Hearing Transcript

Project:	A46 Newark Bypass
Hearing:	Issue Specific Hearing 4 (ISH4) - Session 2
Date:	05 December 2024

Viewpoint 24: Overview of wireframe in operation (cylindrical projection, field of view 180 degrees x 27 degrees)

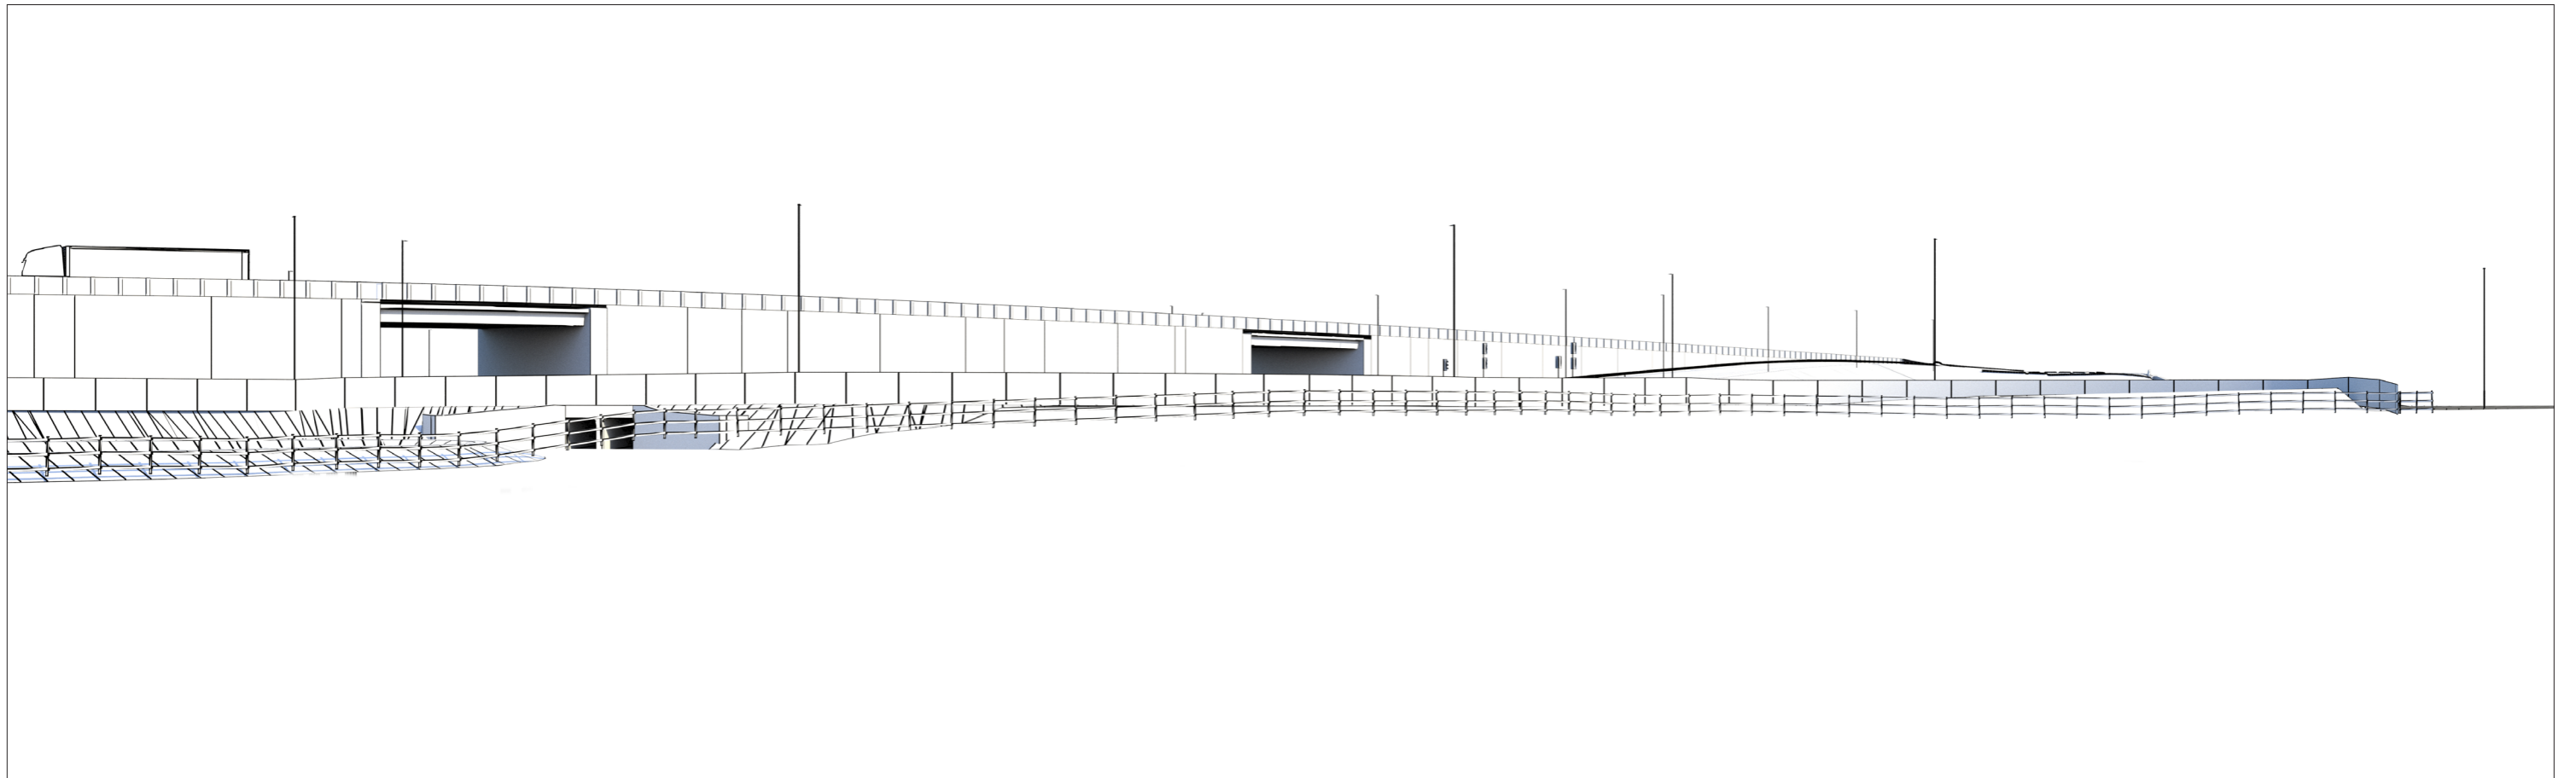
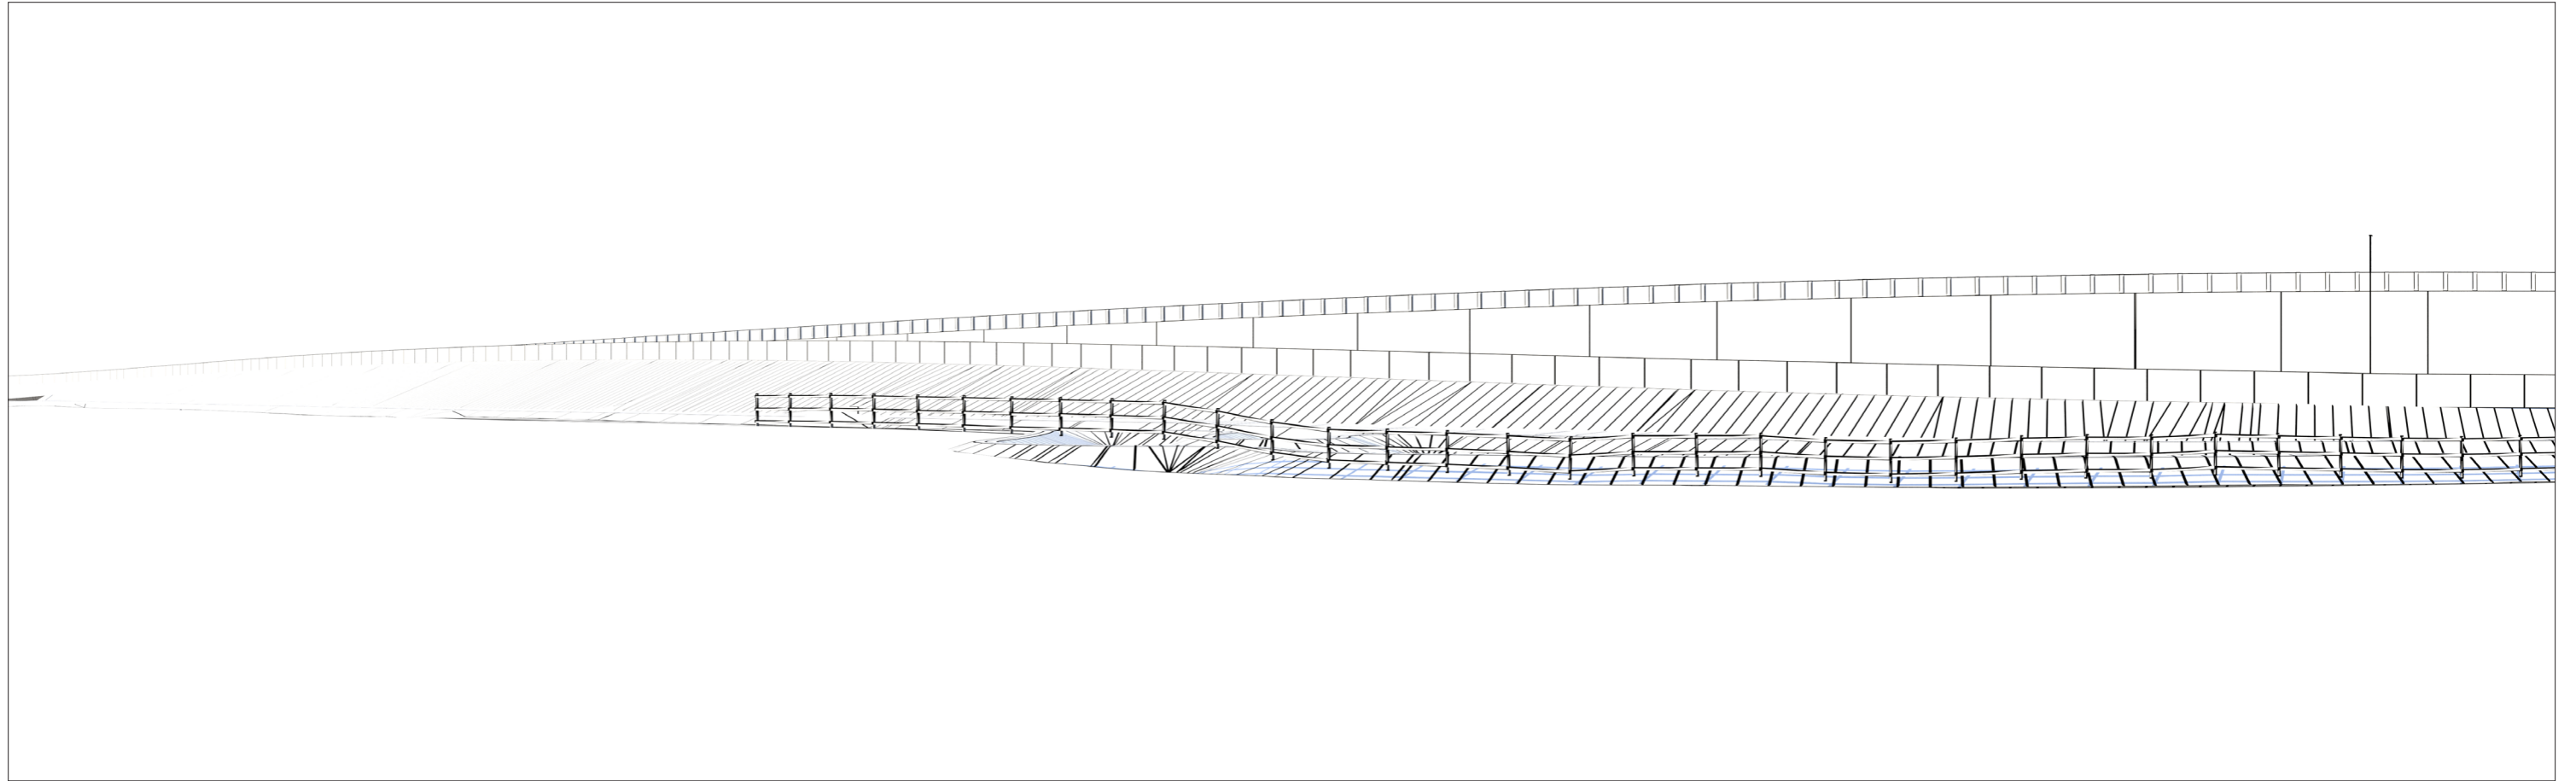
I'd like to start off first of all with in our rule six, letter PD, 005, annex, F, point eight, the examining authority requested further analysis of the sand hills viewpoint that was VP 24 now, I thought the examining authority had set out quite clearly what we were looking for in terms of the expectation, and it was a sort of a 180 degree view with potentially a wire frame supporting that. Can we, can we bring this viewpoint on screen? Please. Should have the Reference number To hand i

Lindsay question for Newark and Sherwood. Yeah, we've, we've made representations as part of deadline three on the visuals that's been submitted. And that's R, E, p3, hyphen, 046, and just in summary, so we do not think that those visuals, especially of sand hills Park, will do anything to allay any concerns of the residents of sand hills park. There's there's nothing that they would be able to see in terms of the impact. All we've got again is that little snip at the end of the cul de sac. I think that it's a bit difficult to say, because obviously the buildings are in the way of any public vantage point. So without having to go into the rear gardens of properties, you can't really experience what they would experience. So I appreciate that in that respect, that would be difficult to produce that visual. I didn't know if there's any other way of trying to represent that for those residents, because obviously they're going from a very flat infrastructure at the minute, which is subside on to the end of those properties, to an A very raised elevated structure, which is approximately Eve's height or above, with the vehicles going across. So that is a massive change for those residents, and I think more needs to be done to interpret how that would be shown. I didn't know whether a visual from the other elevation, so we could probably see the the gradient from the other elevation, maybe from the 617, who could see the full context. So we could, that would be the best way, rather than going to people's gardens, to show the true elevation from from that angle. Yeah, that was our, our interpretation. Anyway,

of paper provided to the examining authority, and I would ask the applicant to consider whether or not a pure wire frame image, so one of these computer generated wireframe images would be useful, and then you would cross reference that would allow us to cross reference what you've produced with the wireframe image. It's something which doesn't take into account vegetation screening. I do appreciate that, but this is about trying to establish the impact on those residents there, and it's about understanding that impact New York and Sherwood. Does that sound like something which you would be happy to receive?

Well, my expectation would be from the position of of VP 24 but of over 180 degree view.

Good morning. Claire Uden for the applicant. Viewpoint 24 captures the view north of sand hills Park representative of views for local residents, as per the rule six requests we've created in an widened extent of view, which say that is wider than the previous photo montage that was produced from this location. And as we can see, there is an area of opacity which defines the wire line for the scheme and its location to the rear properties. Then if we were to scroll down slightly, please on the view, you can see that capital market is then visible with the white rendering. So the areas of white are those areas that will be seen, whereas the areas of a property are those that would be hidden by intervening built for

didn't for the applicant, the views will vary depending on the angle of view and the direction of view that's afforded by the properties. The majority of properties afford oblique views, so they won't be having direct views towards cattle market itself, and certainly from the lower image, I think it's fair to say that actually the alignment of the road as it reduces down from the grade separated junction would actually be quite some distance behind these properties. And in fact, the compound itself would be directly at the rear of those three properties that we can see on that image.
